Our Case Number: ABP-317660-23

Re: Busconnects Kimmage to city centre core bus corridor scheme
Kimmage, Dublin

KIMMAGE TO CITY CENTRE CORE BUS CORRIDOR SCHEMELANDSCAPING AND URBAN REALM

Programme Title BUSCONNECTS DUBLIN CORE BUS CORRIDORS INFRASTRUCTURE WORKS				
Drawing Title KIMMAGE TO CITY CENTRE CORE BUS CORRIDOR SCHEME LANDSCAPING AND URBAN REALM				
Drawing File Name BCIDD-ROT-ENV_LA-0011_ML_00-DR-LL-0001	Sheet Number 01 of 14	Status A	Rev M01

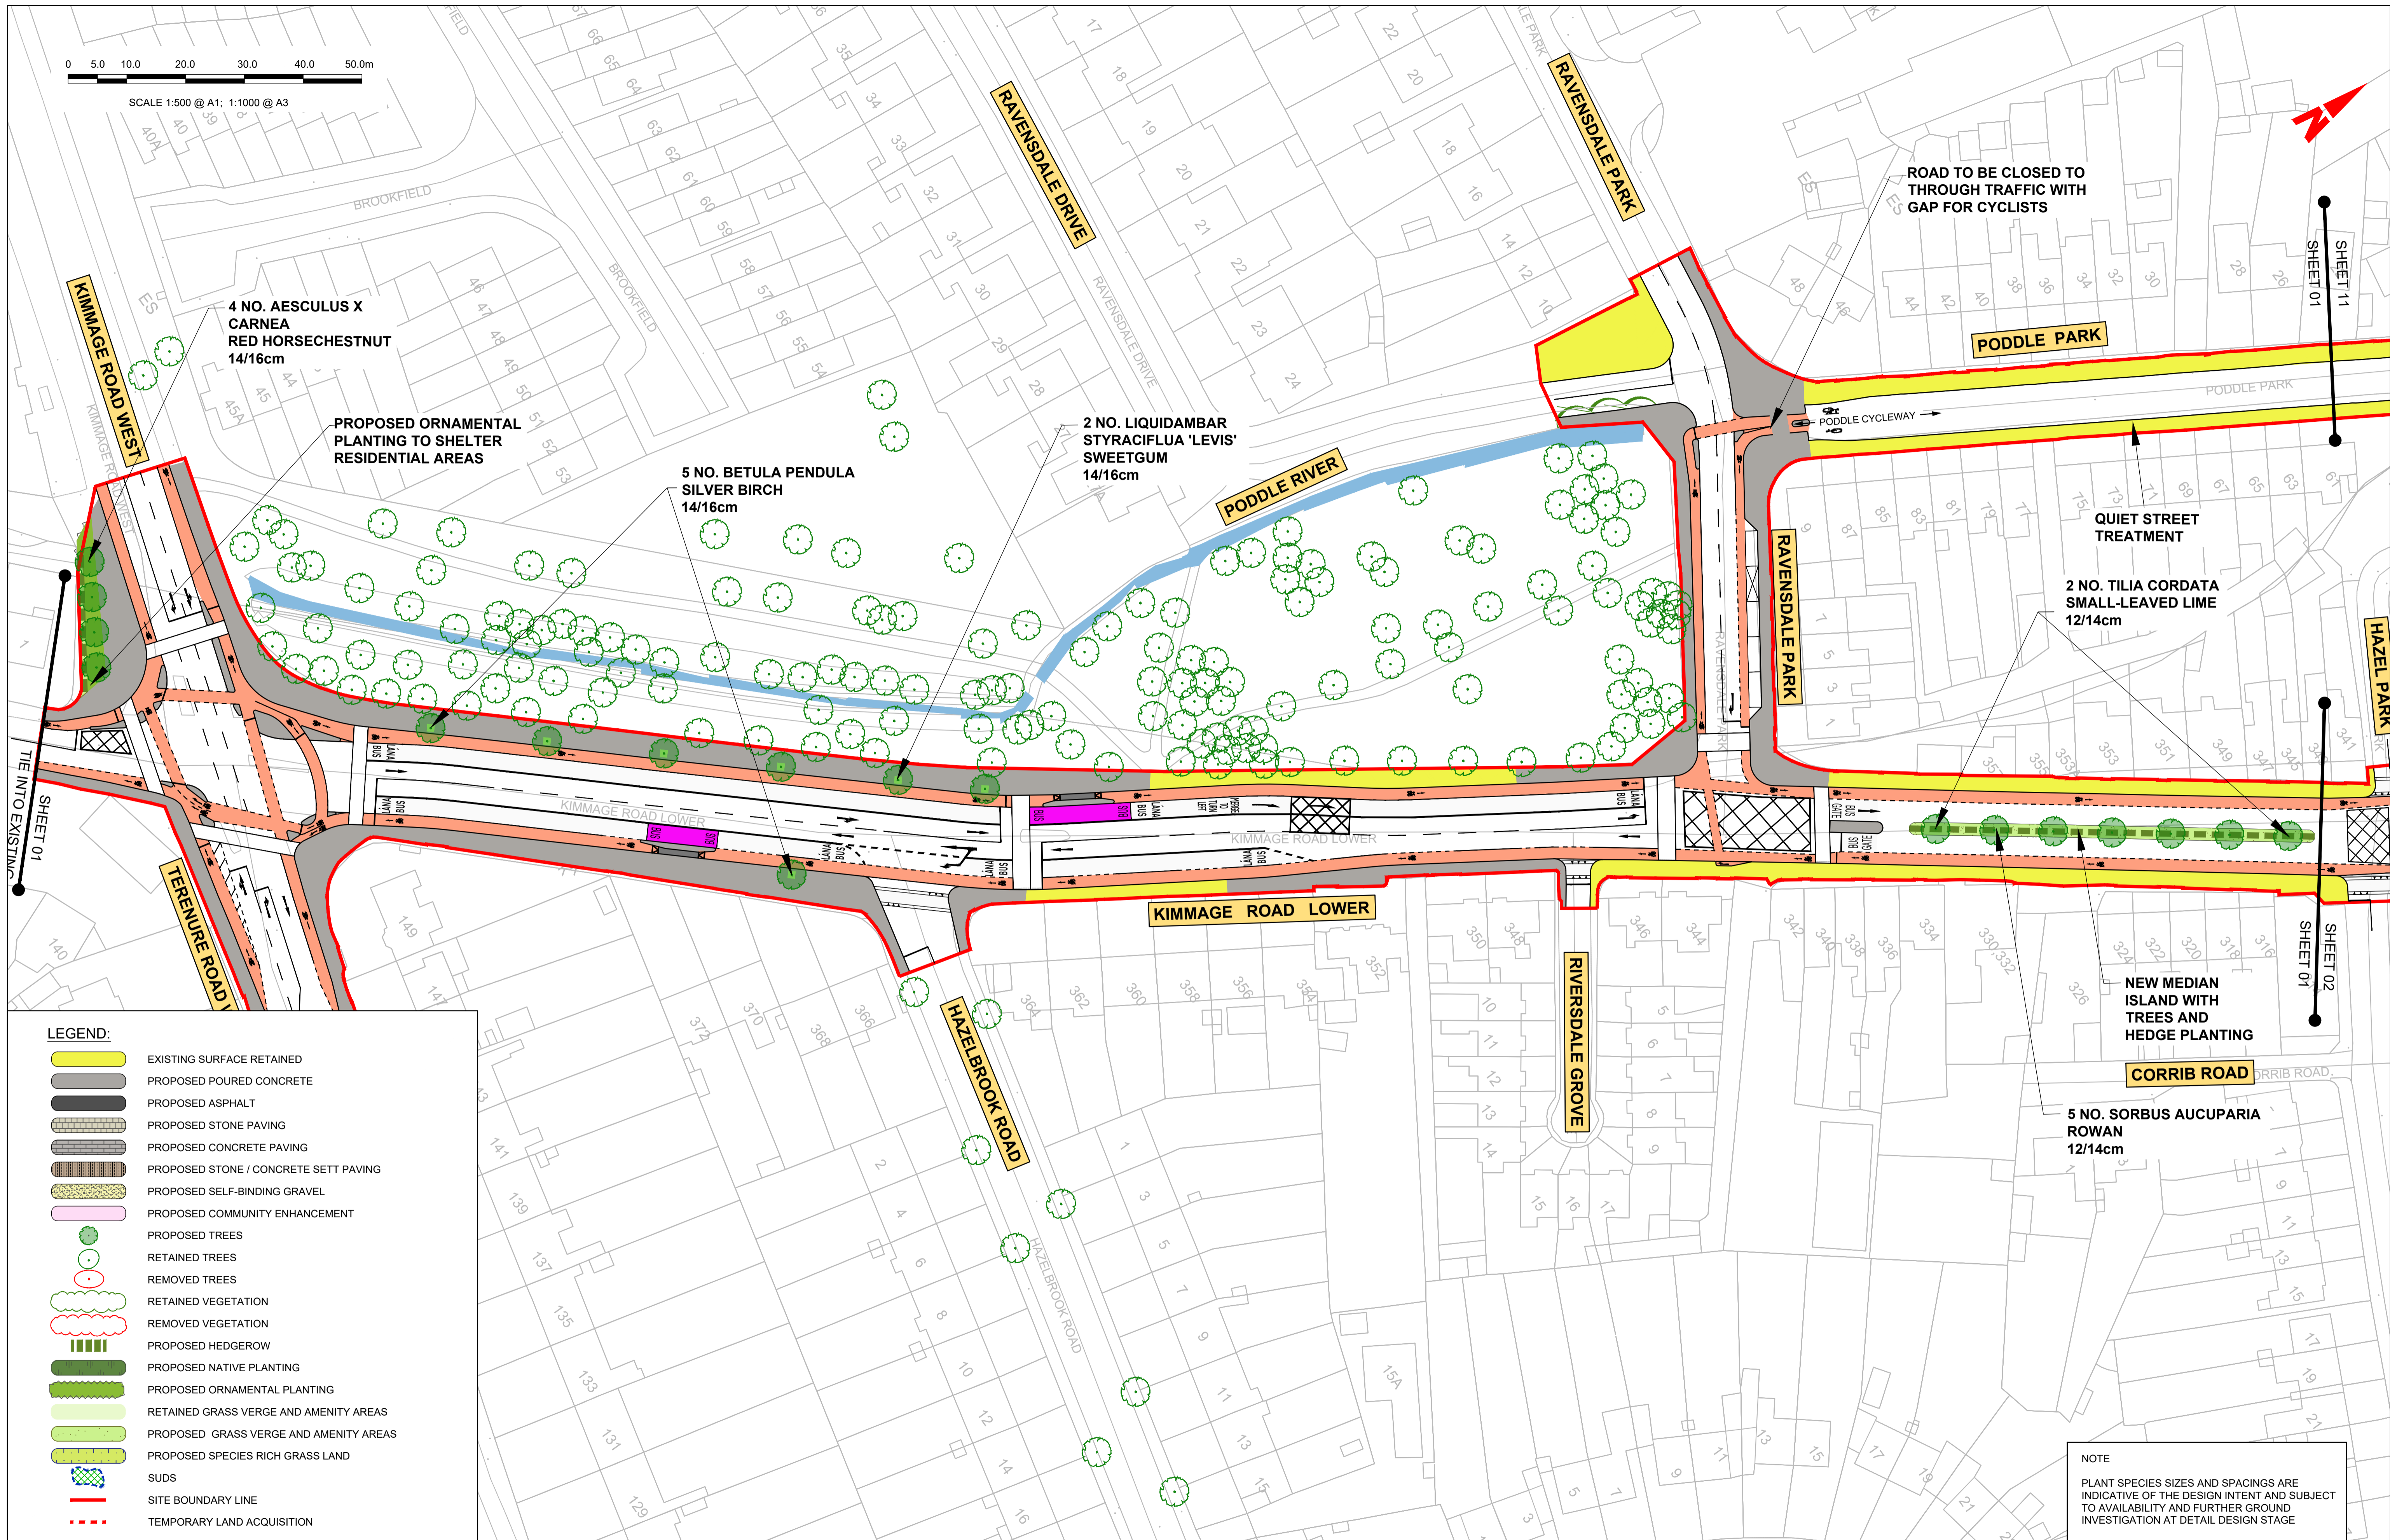
More ambitious provisions of new trees should be provided while works are underway to promote sustainability. Existing trees outside boundary line of works have been included which suggest more trees are being installed than it appears until legend is read. Works outside red line is not relevant and they should be not be included on the application as it appears to overstates trees actually being provided.

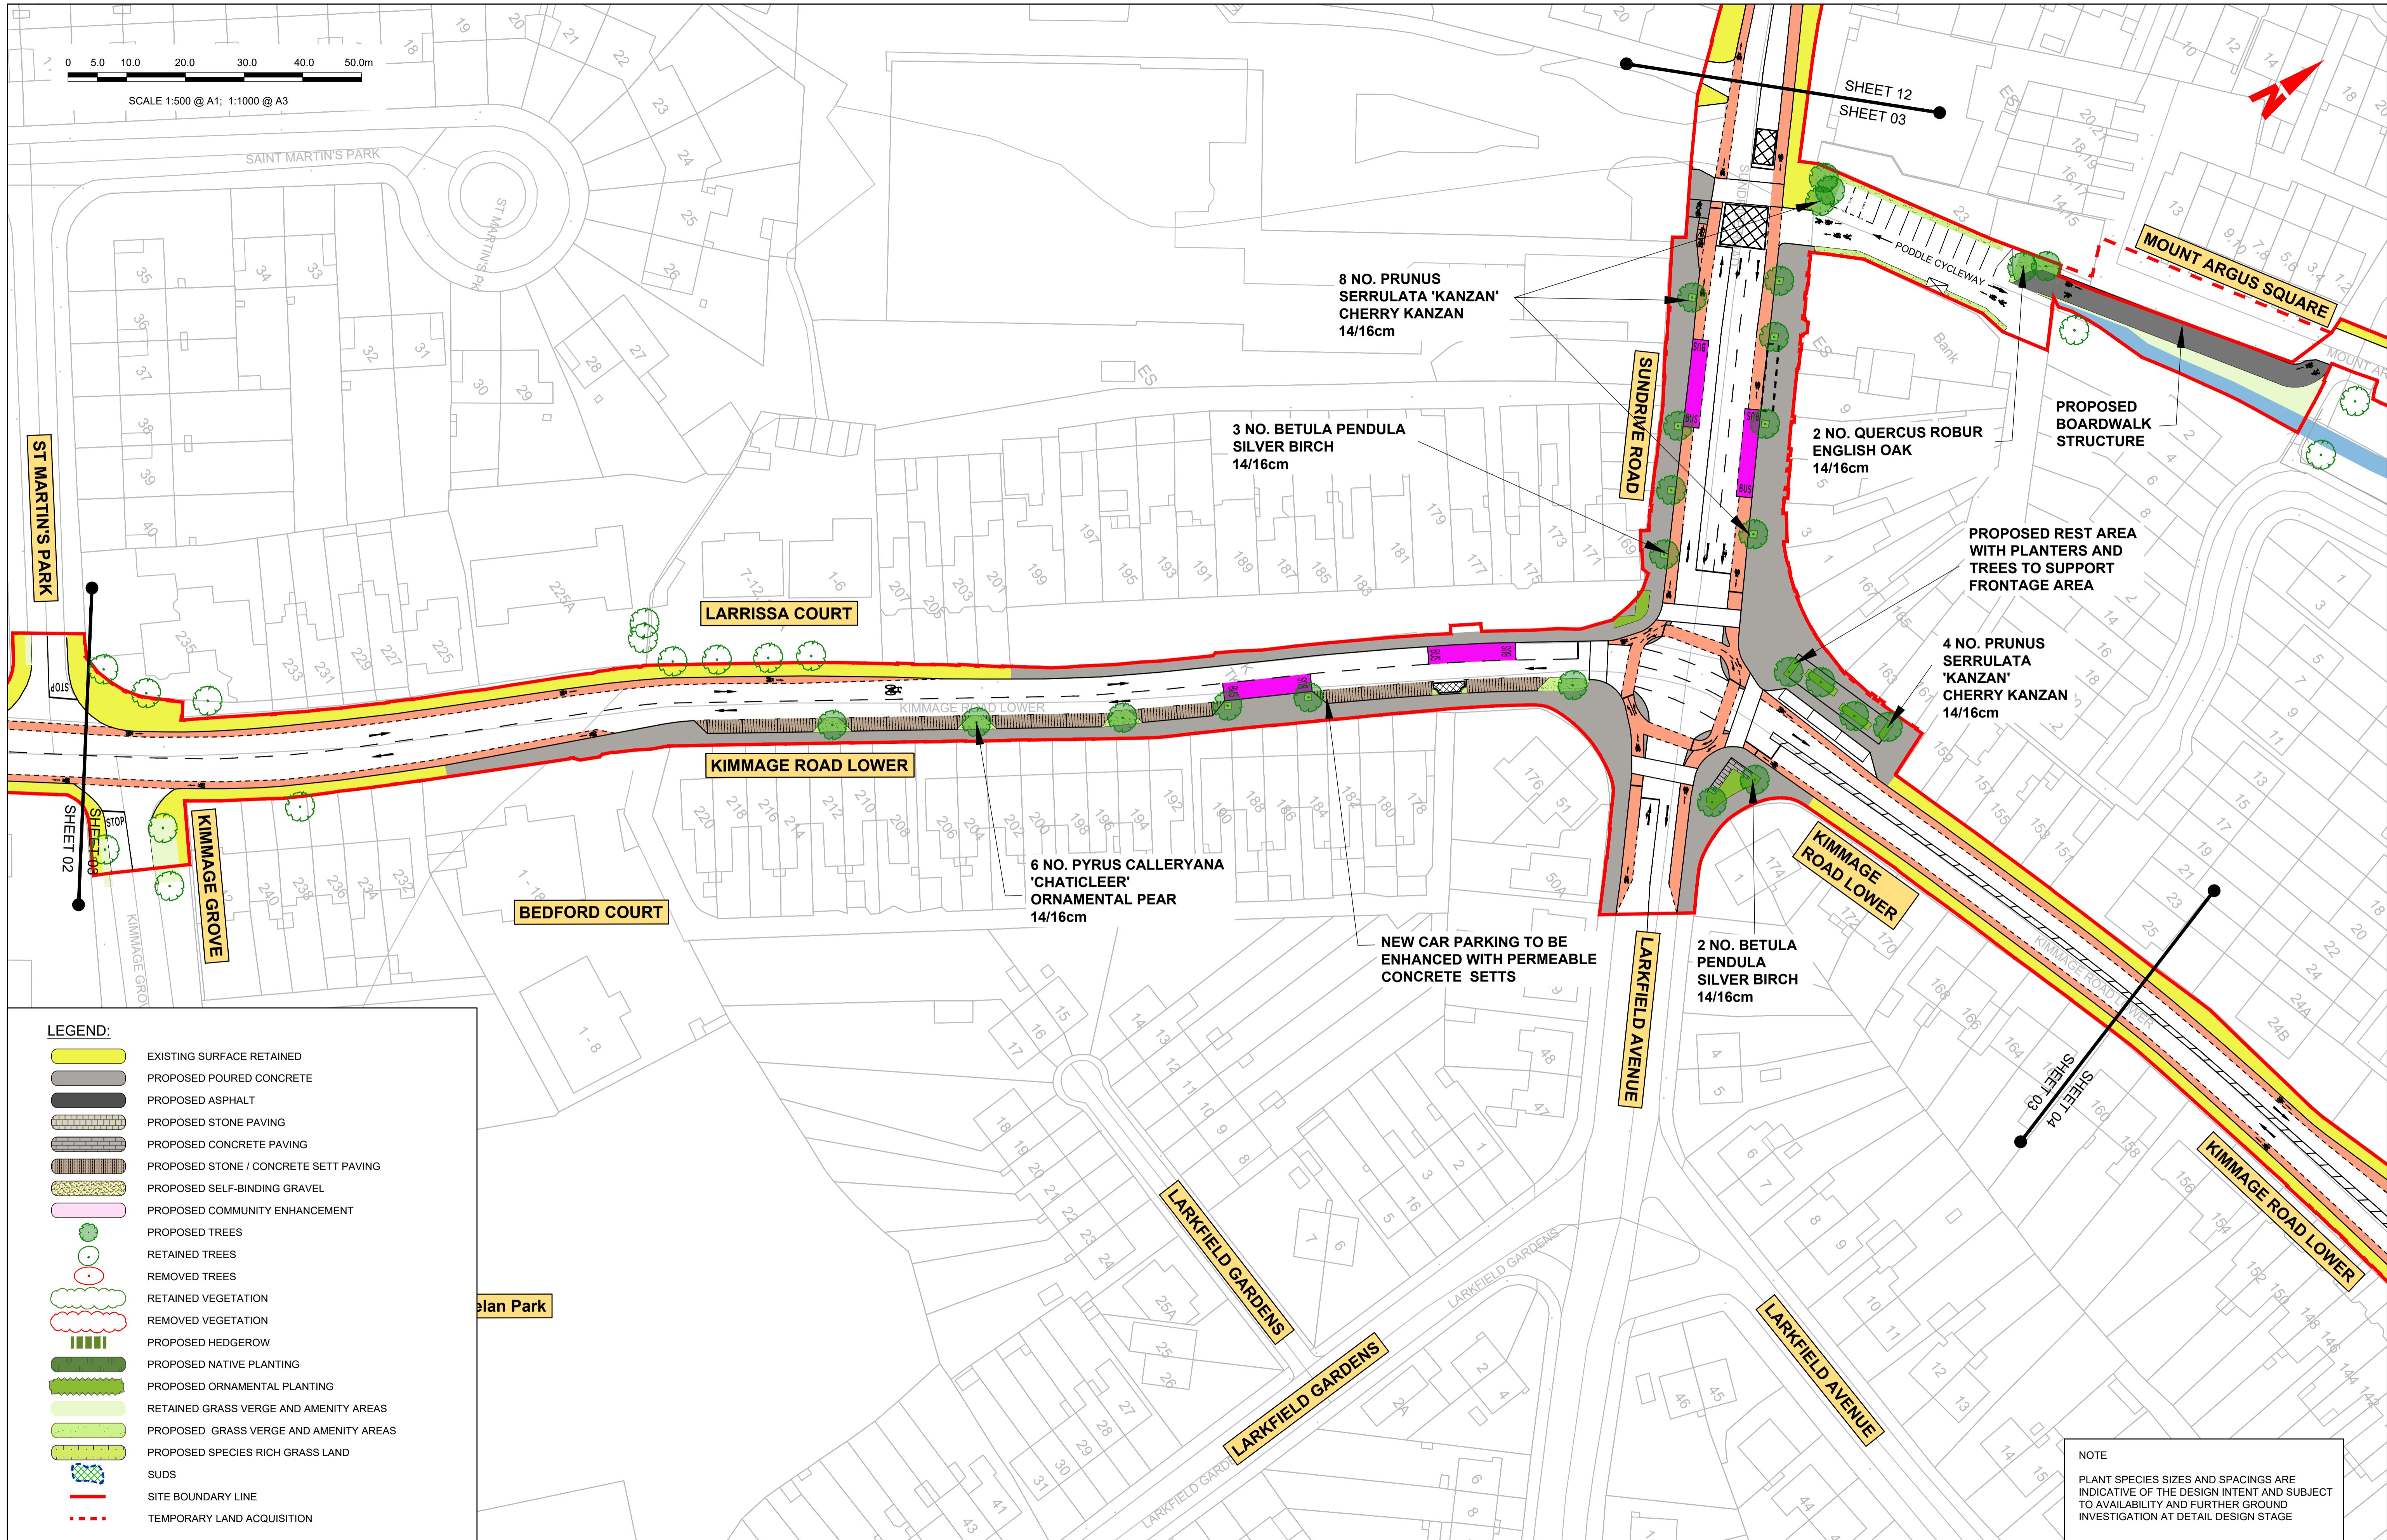
There are existing telephone / light / sign poles which are poorly located which prevent two way traffic due to minimum distance between poles & boundary wall to footpath. It is an particularly an issue when meeting with prams or wheelchairs The concrete foot paths have been shown as yellow indicating no amendment to locations. These poles should be repositioned while the improvement works are underway. Suggest survey carried out to determine locations to full layout (sheet 1 – 14) and correct amend within layouts. See below photo for example

There are less tree provisions being provided to Lower Kimmage Road / Sundrive Rd road junction than was shown in the preferred route PDF issued previously. Suggest increasing.

There is an opportunity to provide high quality amenity space to Sundrive Road / Lower Kimmage junction and surround. Granite / stone paving should be used to promote foot traffic / community . sustainability and more ambitious public landscaping / street furniture should be provided.
